**From:** Joyce Christie <Joyce.Christie@Cherwell-DC.gov.uk>  
**Sent:** 08 May 2025 16:36  
**To:** Shona King <Shona.King@Cherwell-DC.gov.uk>  
**Cc:** DC Support <DC.Support@cherwell-dc.gov.uk>  
**Subject:** 25/00871/F Chancel Cottage

Title
EXISTING SITE PLAN

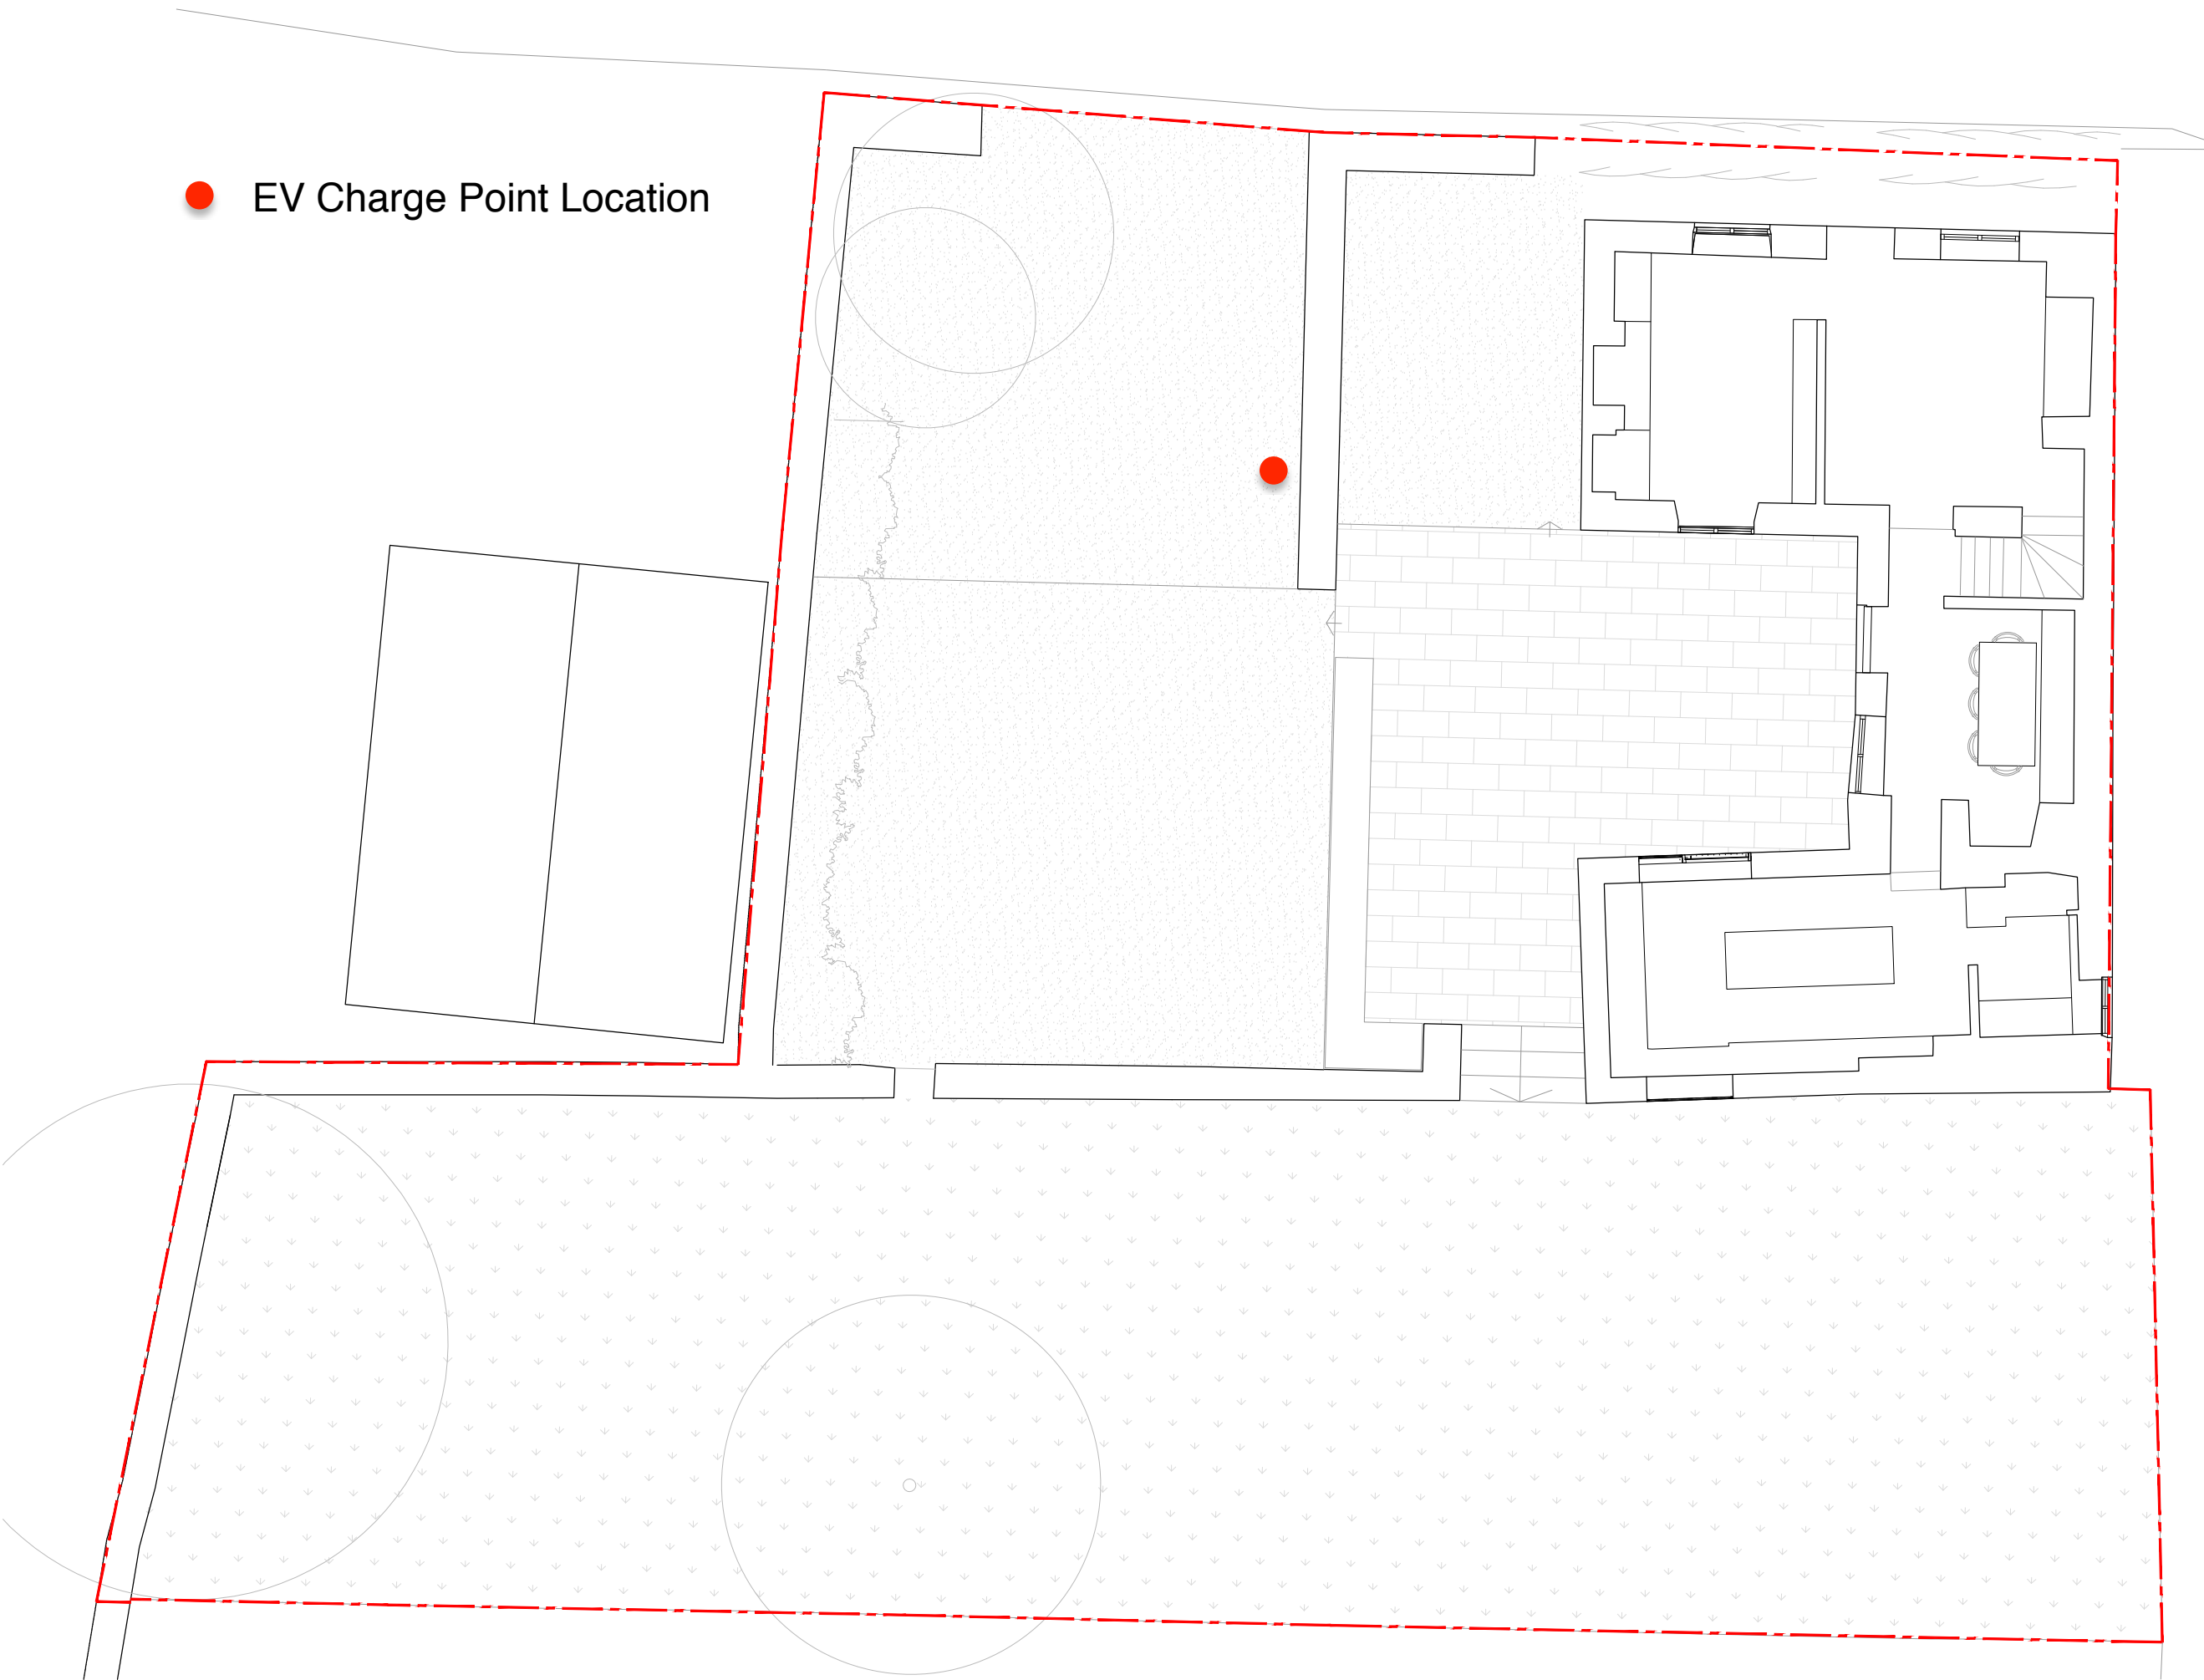
We support an independent charger on a pole as opposed to fixing to listed fabric but wondered if the post could be located on the north side of the wall with the charger facing south above the coping, set against the backdrop of the hedge to reduce the impact on the views?
